From: Amanda Scholes on behalf of Planning.Responses
Sent: 31 May 2017 08:51
To: Planning Scanning
Subject: FW: Planning Consultation on: LU/121/17/RES

Comment from Greenspace

Registered: 19th April
2017
Site Address: Land North of Toddington Lane Parcel C1 & part
Parcels B2, B4 & C2 Littlehampton BN17 7PP
Grid Reference: 503051 103950
Description of Works: Approval of reserved matters following outline
consent LU/47/11/ for construction of 126 No.
dwellings together with internal road network, car
parking & landscaping.

Proposed planting: LA104
4 of 5

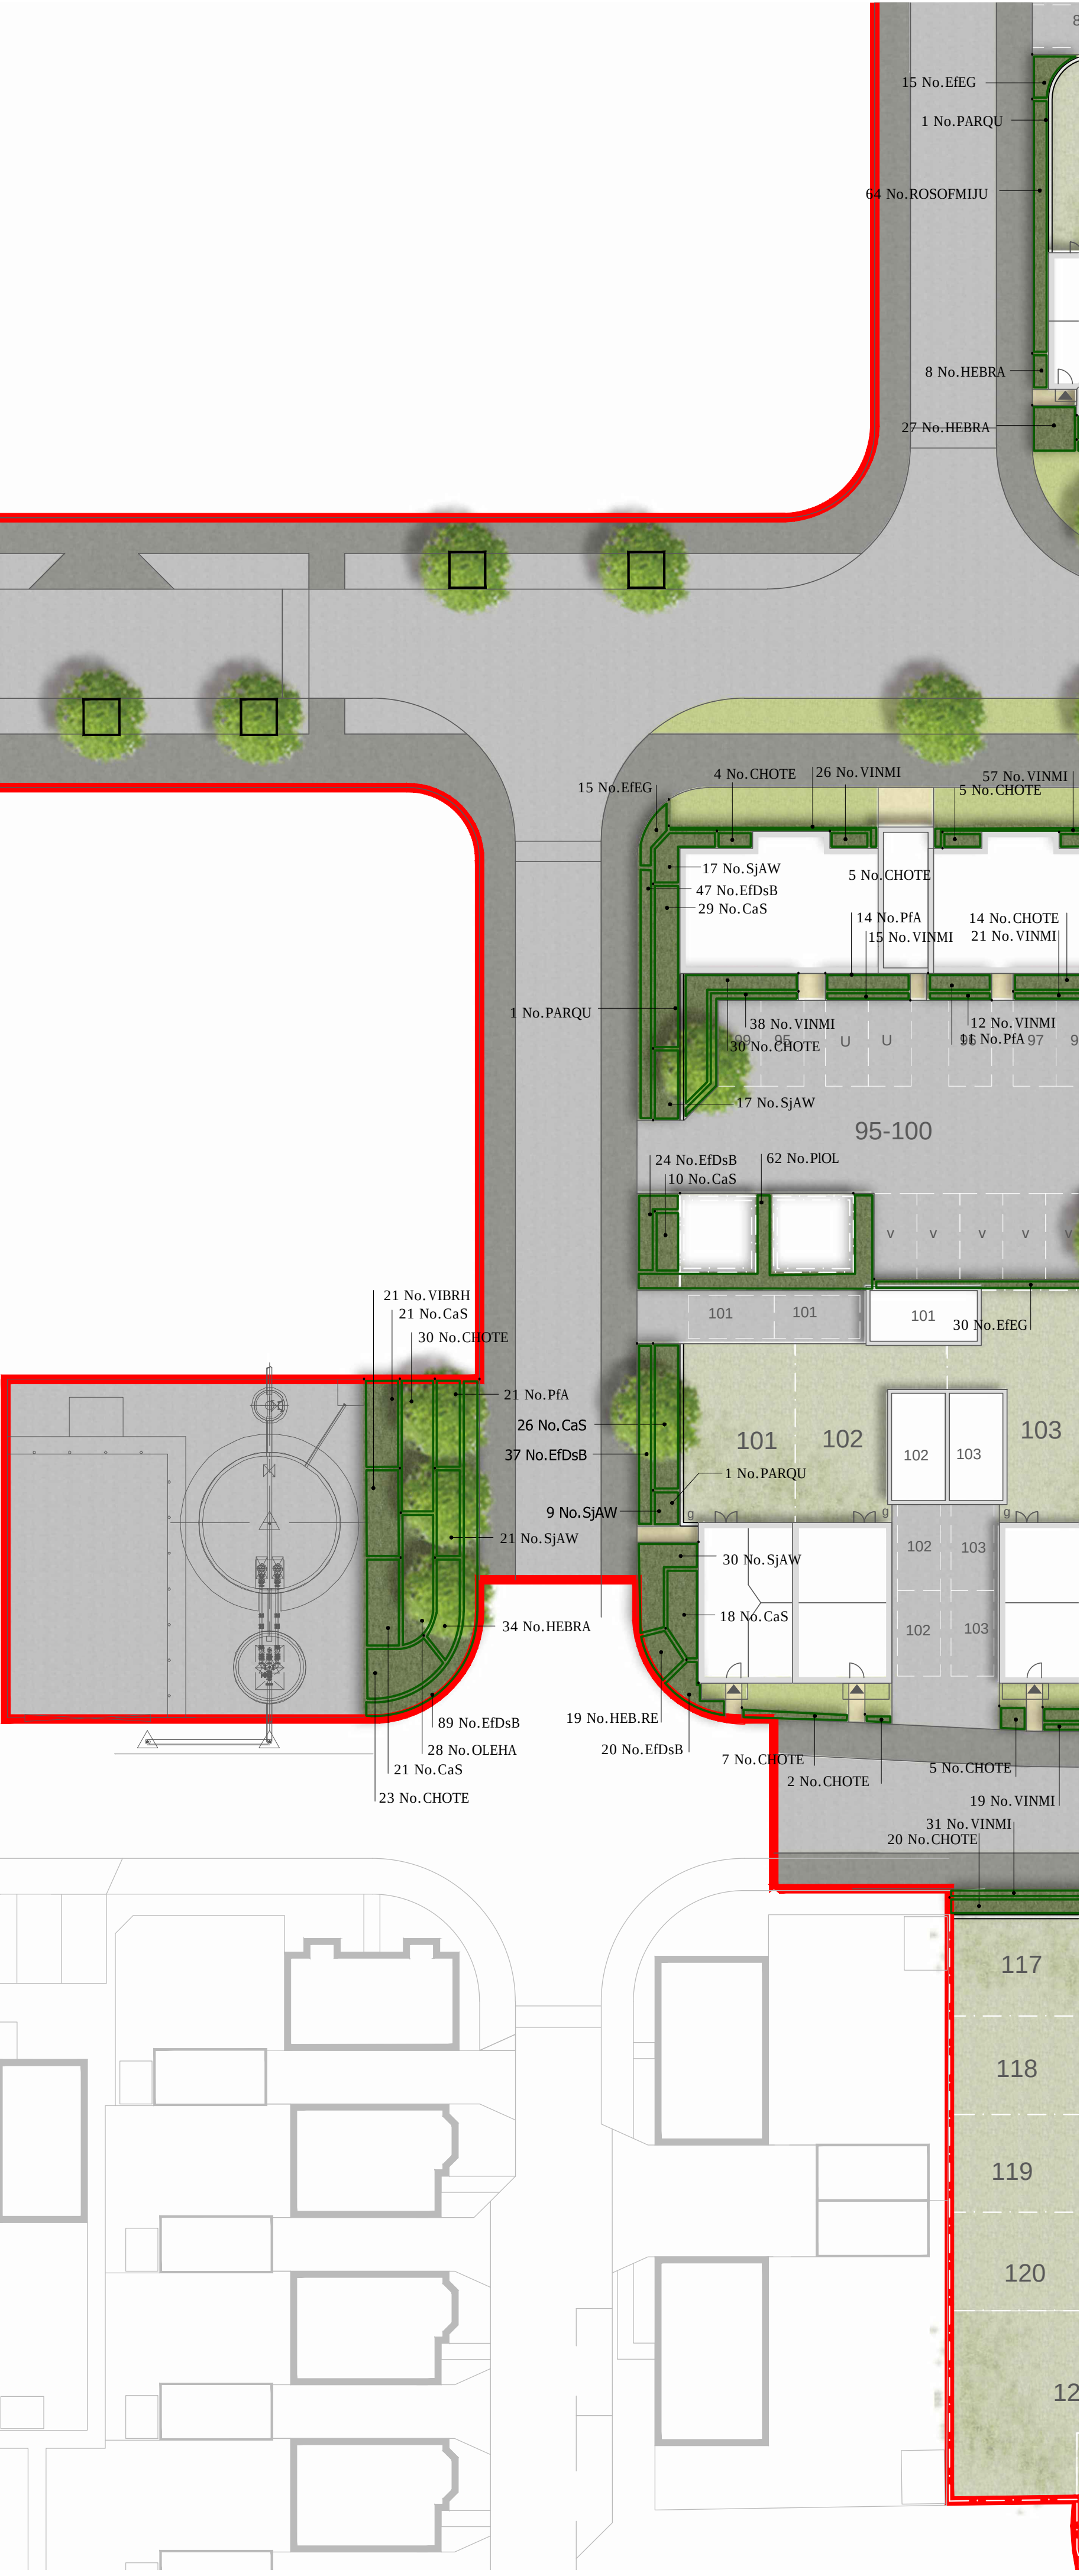
The general scheme proposed in Proposed planting drawings LA101 –LA105 provides a well thought out and comprehensive scheme which has provided a good mix of both native and ornamental species and trees at a suitable size at planting to provide instant impact to this development. The scheme proposed has provided detail in plan form with species choice, plant numbers and densities and size at time of planting. A maintenance specification has been provided and it should be confirmed who is to be responsible for the implementation of this, with S106 monies concluded if this to be the responsibility of the Local Authority going forward?

LA106

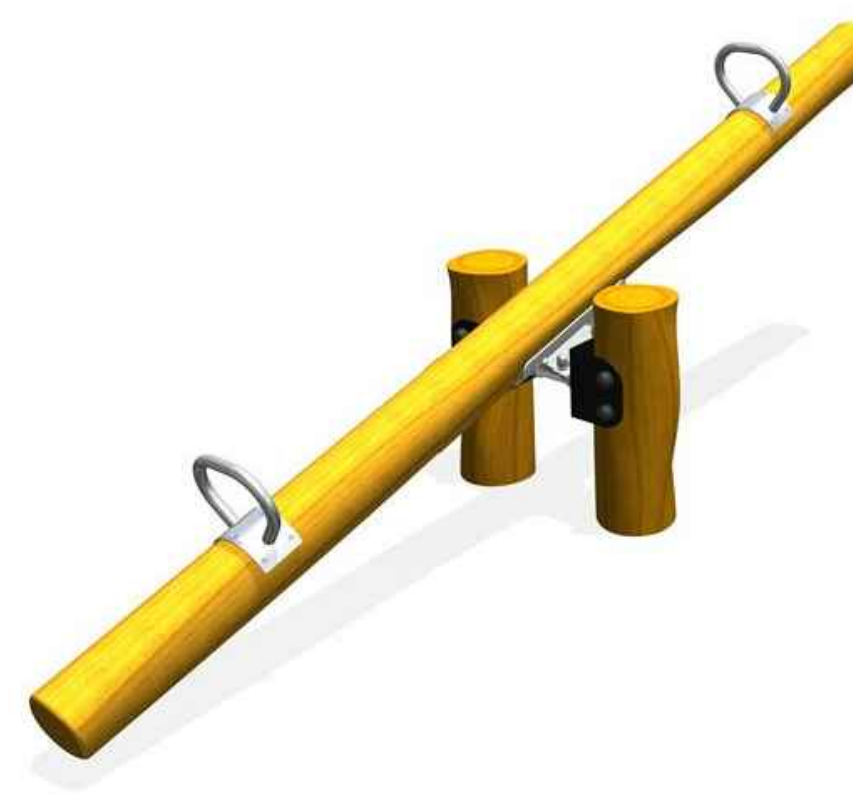
The LEAP Play proposals LA106 contained within drawing A0088461 LA100-107.dwg, although rather tucked away in its location rather than centrally met, does provide a good play experience with a variety of play experiences being provided for this younger age range. We would ask for clarification to confirm if this is proposed to be a fenced/gated play area or unfenced play area? because of its proximity to the adjacent parking/road. We would recommend that a ROSPA inspection is completed for this proposal.
